Dogger Bank South Offshore Wind Farm

Appendix B6 to the Natural England Deadline 6 Submission
Natural England's comments and updated advice on Marine Physical Environment

13th June 2025

Appendix B6 – Natural England’s Advice on Marine Physical Environment at Deadline 6

Figure: 8-5	Drawing No: PC2340-RHD-OF-ZZ-DR-Z-0627	
Co-ordinate system: WGS 1984 UTM Zone 31N	Page Size: A3	Scale: 1:900,000
Project: Dogger Bank South Offshore Wind Farms	Report: Environmental Statement

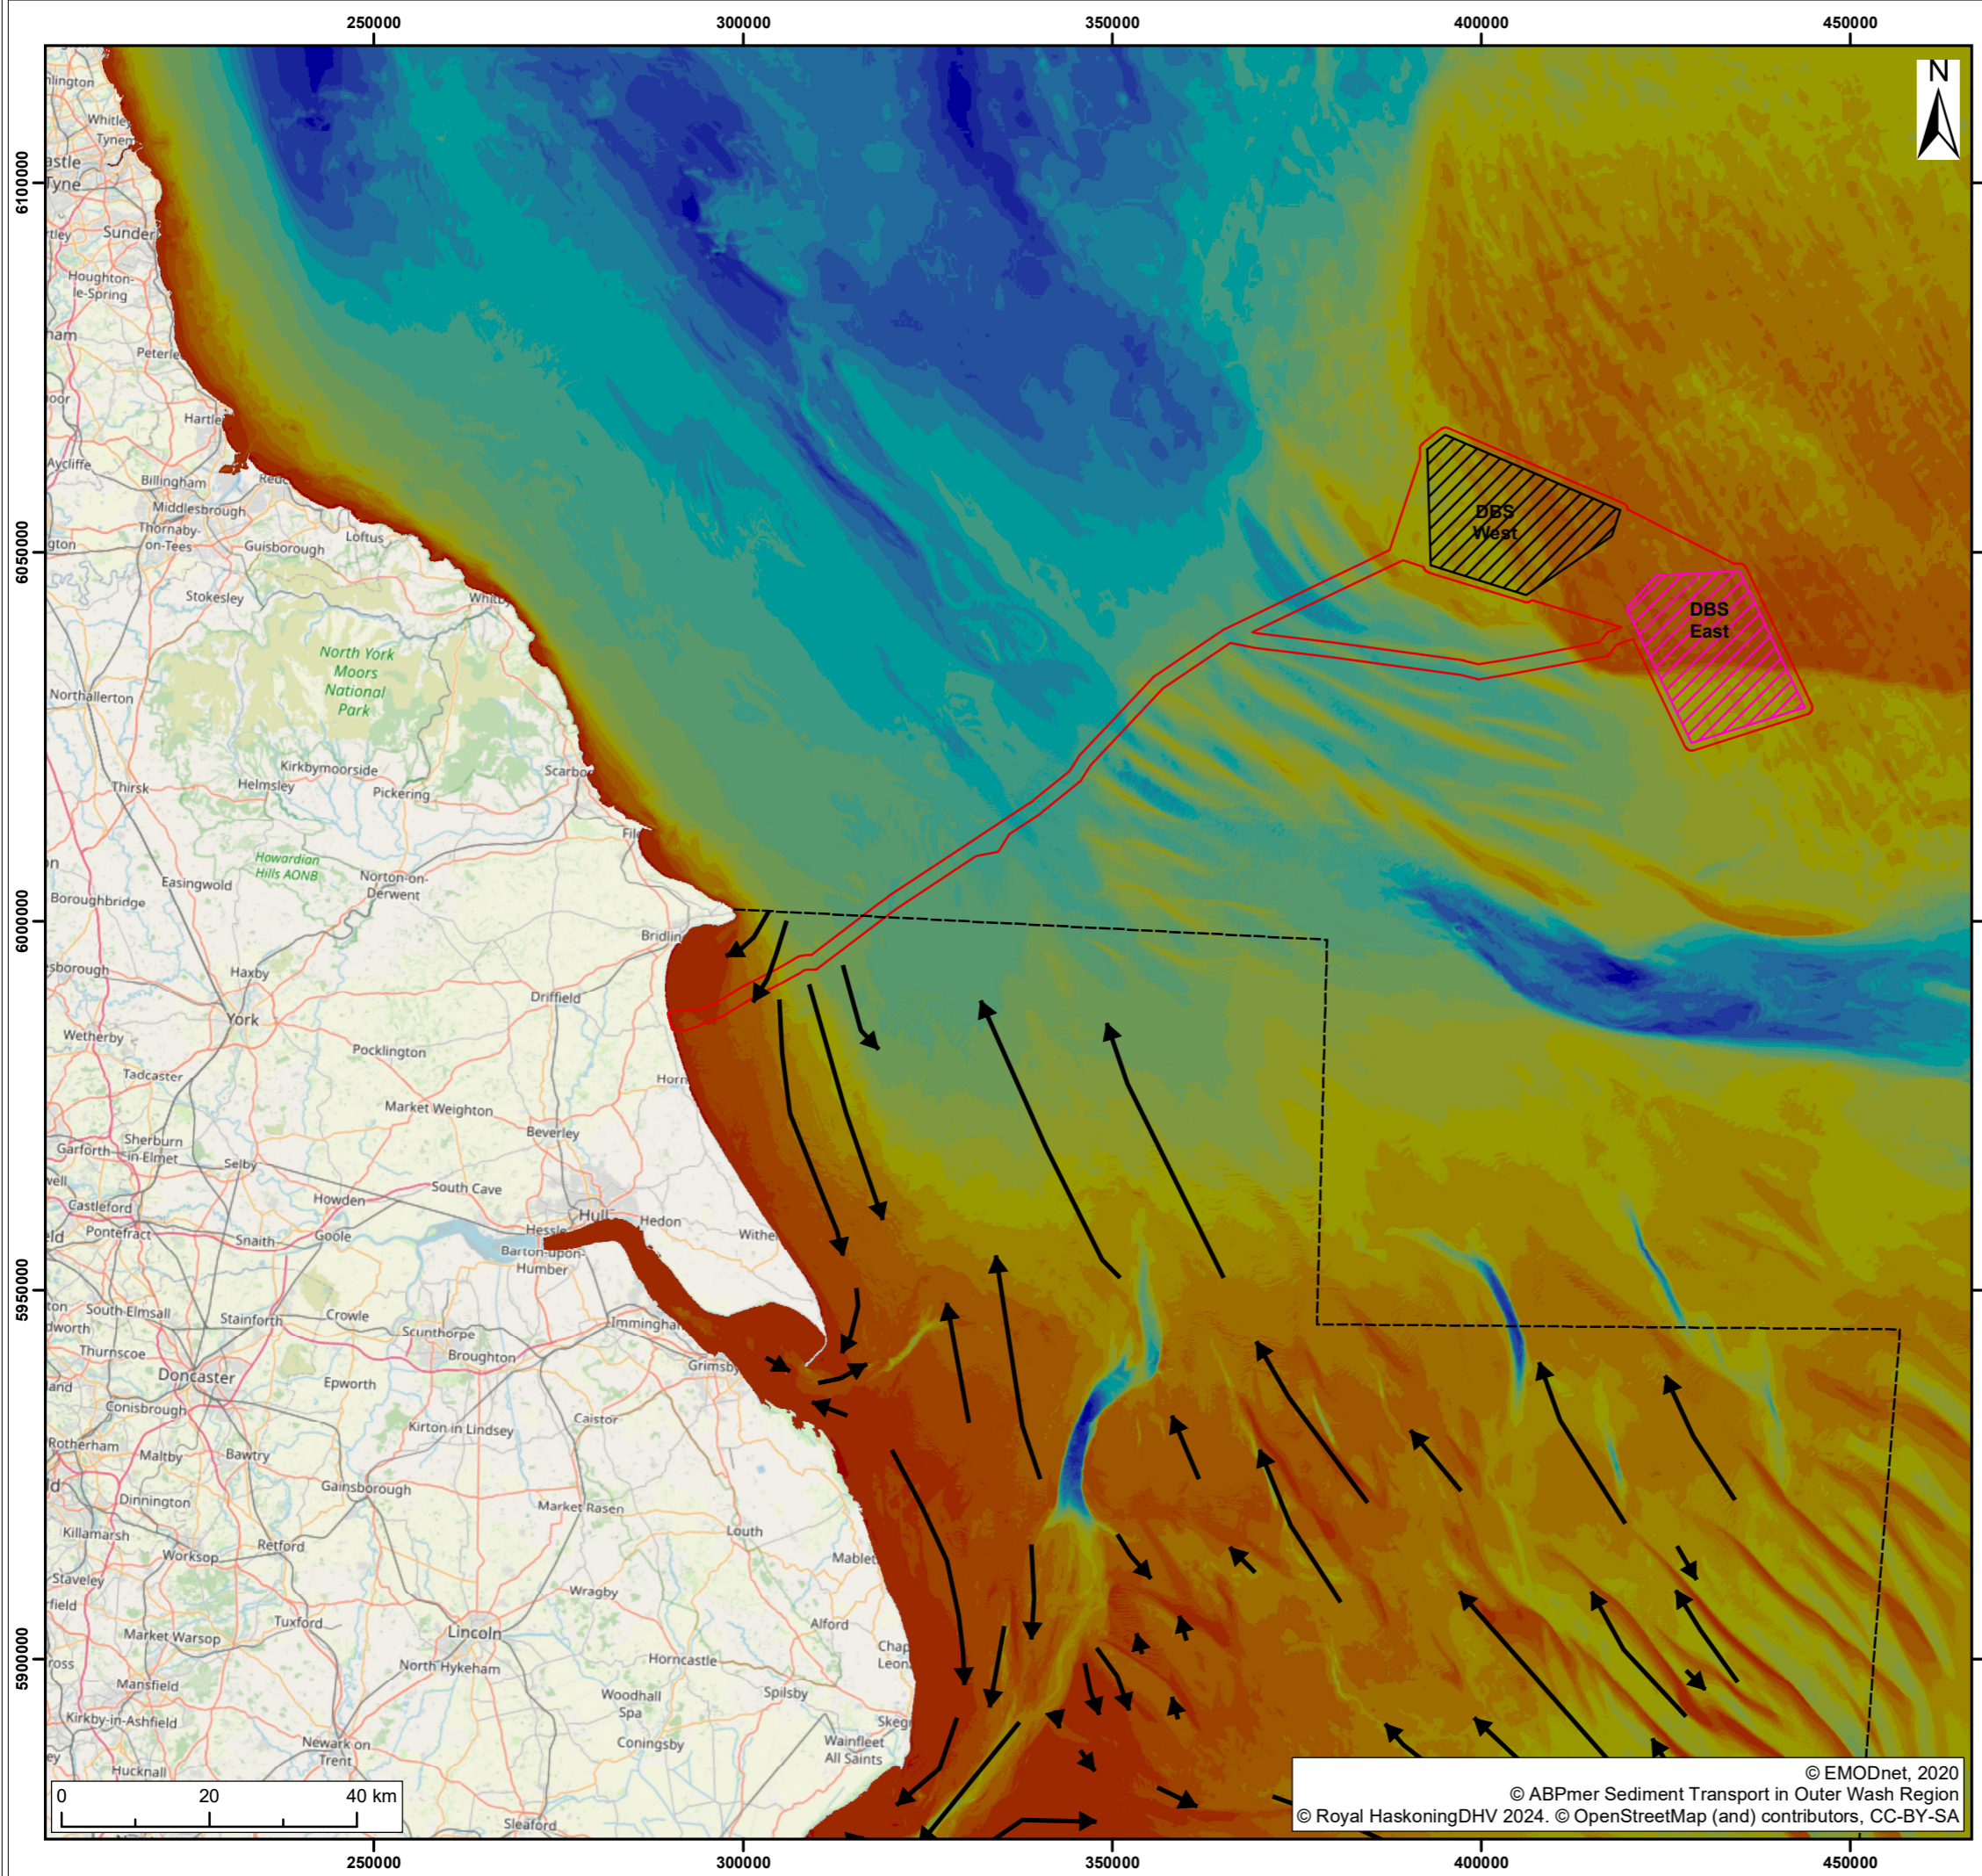
2	Figure 6-5/8-5	Natural England welcomes the Applicant's further assessment and information on sediment transport pathways including from 35km seawards of Landfall offshore and around the western/southwestern Dogger Bank area.	Natural England considers this issue to be resolved. [R&I, B9]
3	Figure 3-1/C-1	Natural England notes that the estimated worst-case length of cable protection in the nearshore environment has been presented relative to nearby marine physical environment receptors (e.g. SACs, SPAs and Smithic Bank) however, it does not include Holderness Inshore MCZ.	<p>We advise that the worst-case location of the nearshore cable protection should also be considered relative to Holderness Inshore MCZ.</p> <p>[R&I, B51]</p>
